2015 Financial Assurance Estimate Form (with pre-plat construction)

Project Information: 5908 Bradley Rd.	
	3/1/2018
Project Name: Springs at WaterView	Date

PROJECT SPRINGS AT WATERVIEW
SHEET TITLE GRADING AND EROSION CONTROL PLAN
FROM _____ TO _____
JOB NO. 0001-02-16-01 SHEET 12 OF 22

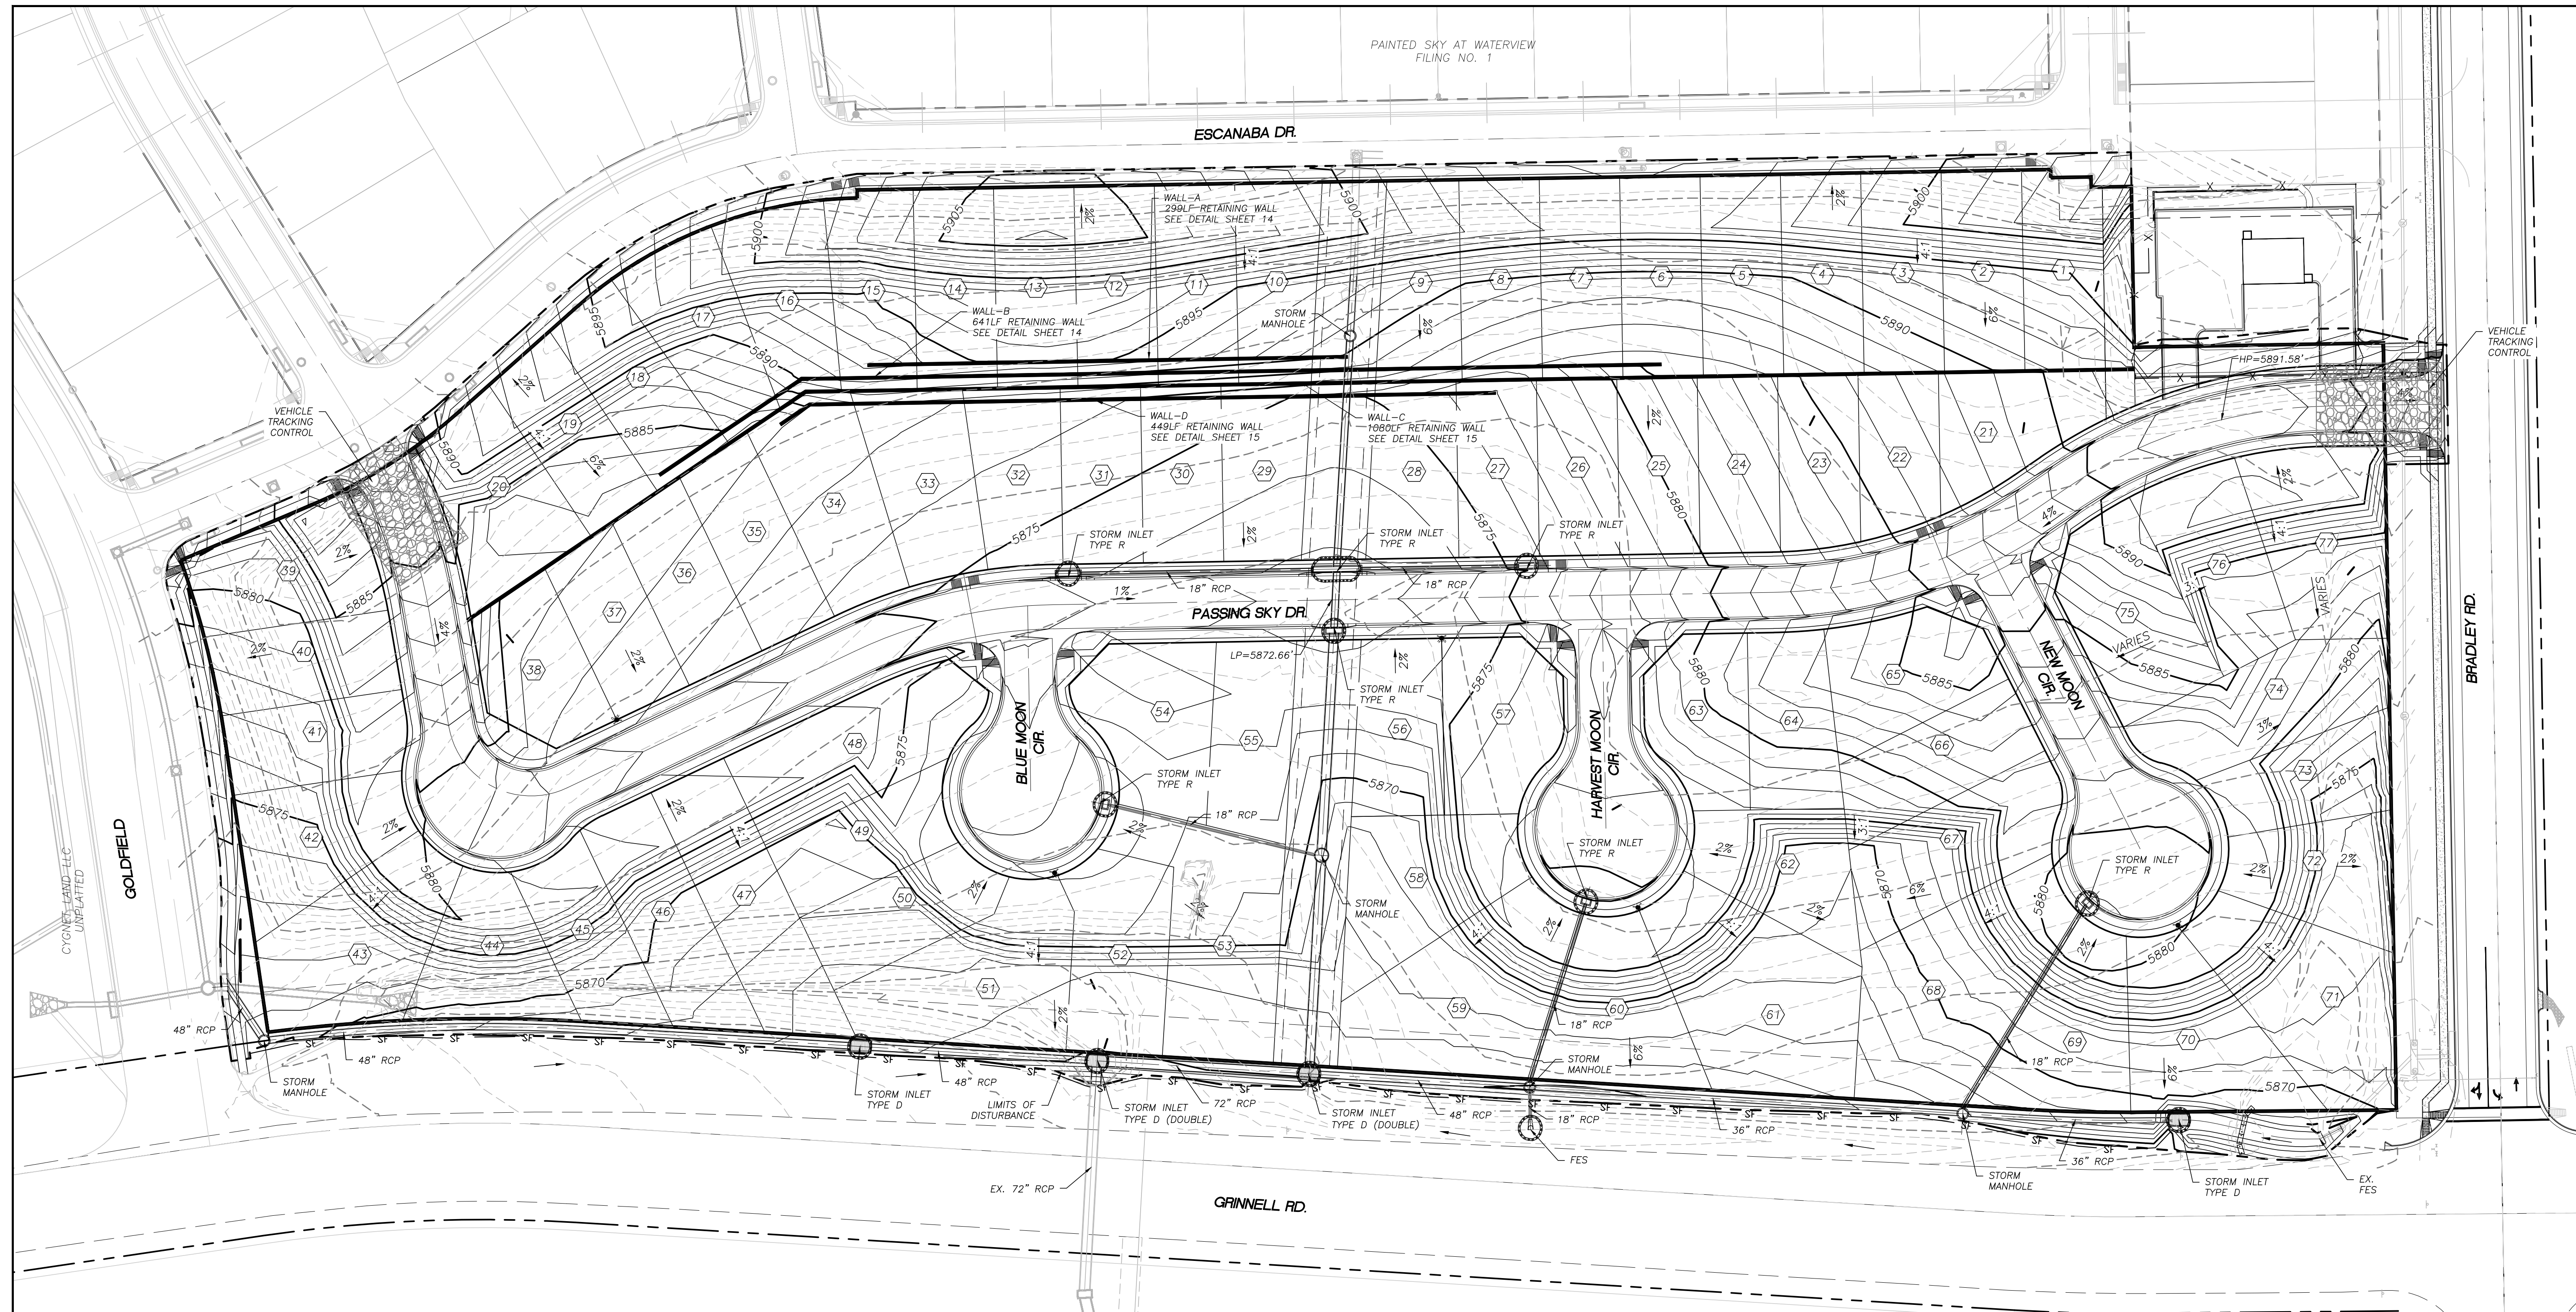
Include the Straw Bale Barriers shown on the grading plan
